Development Control
Ribble Valley Borough Council

App no: 24.1027

Address: Longridge Recreation Ground, Kestor Lane, Longridge

Proposal: Discharge of conditions 3 (construction method statement) and 4 (details of contractors compound) from planning permission 3/2024/0656.

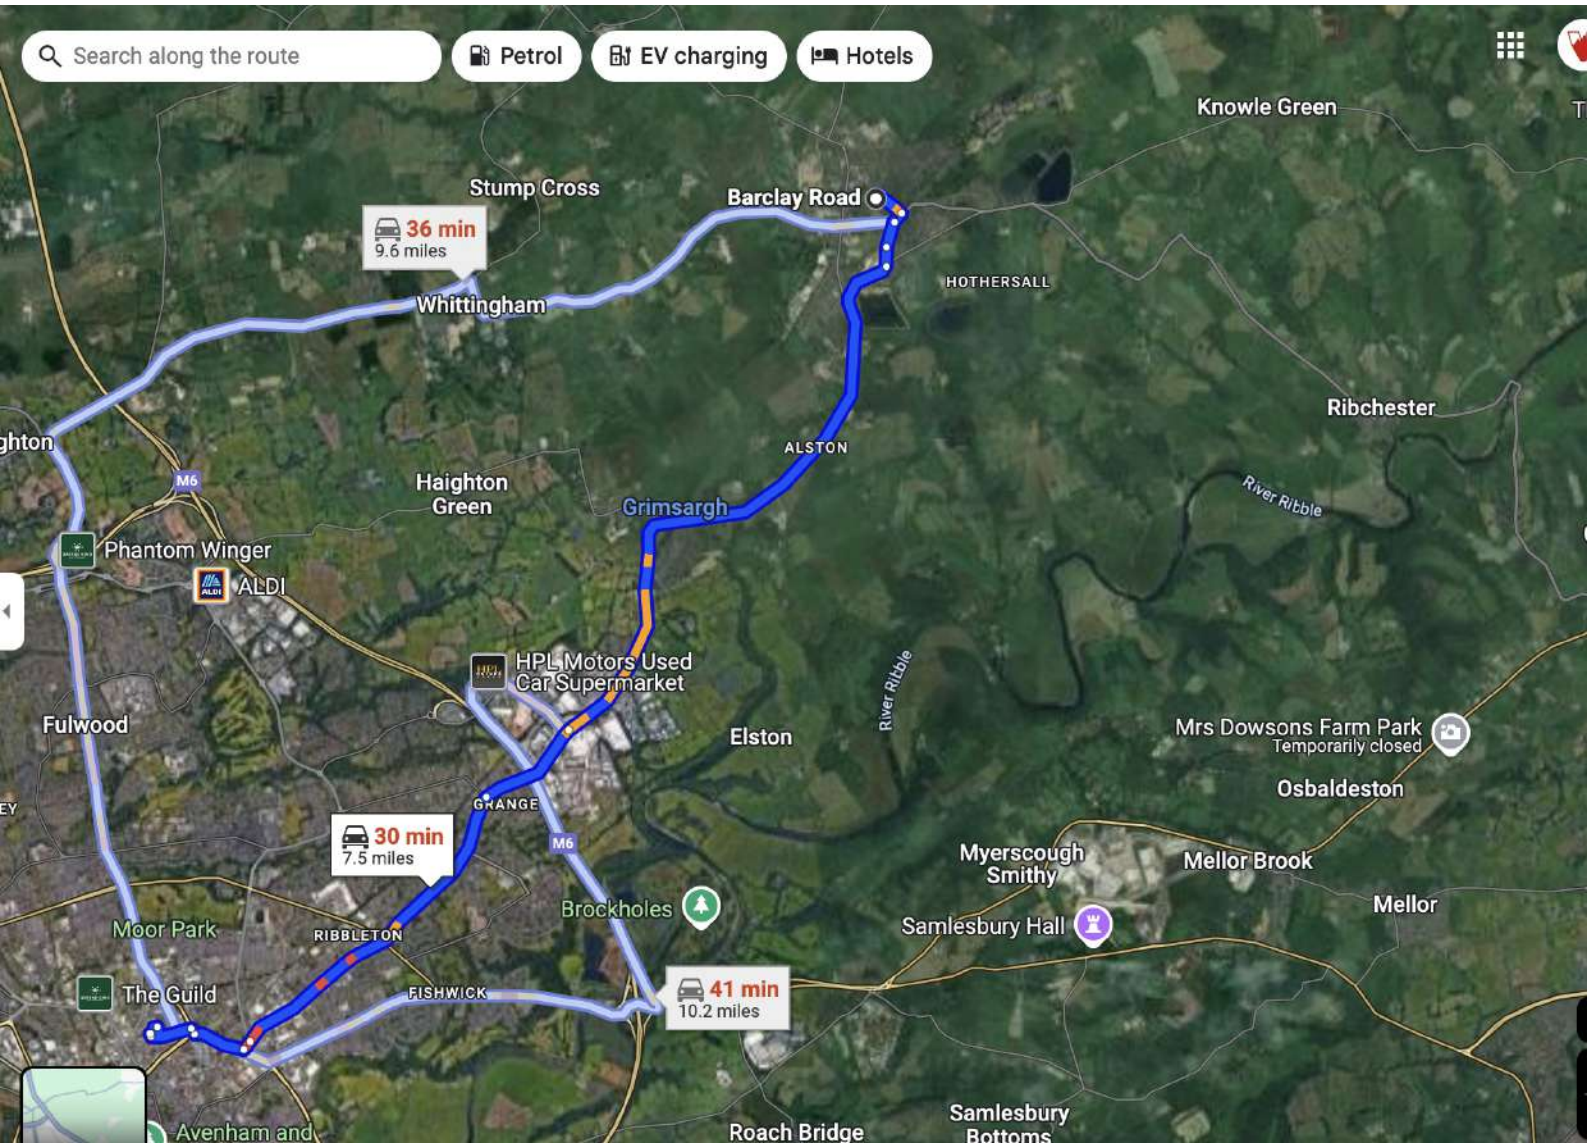
Construction vehicle access will be taken from Barclay Road and along the park access which carries public footpath FP03-02048 for approximately 55m. There will be a temporary access laid in aluminium trackway to the site which will provide operative parking, welfare, storage and a vehicle turning area.

There are no details included for the frequency of vehicle movement to/from the site or the length/timing of the project. This would influence our comments regarding the protection of pedestrians on the public footpath. The proposal doesn't include any measures to separate or protect pedestrians and cyclists from construction traffic movement sand with the paved path being approximately 3 wide this would be a concern should vehicle movements be frequent at busy times during the warmer months. Should pedestrians and cyclists need to step off onto the adjacent grass for passing vehicles then this would be a concern during the wetter months. We would request some additional information is provided to allay these concerns.
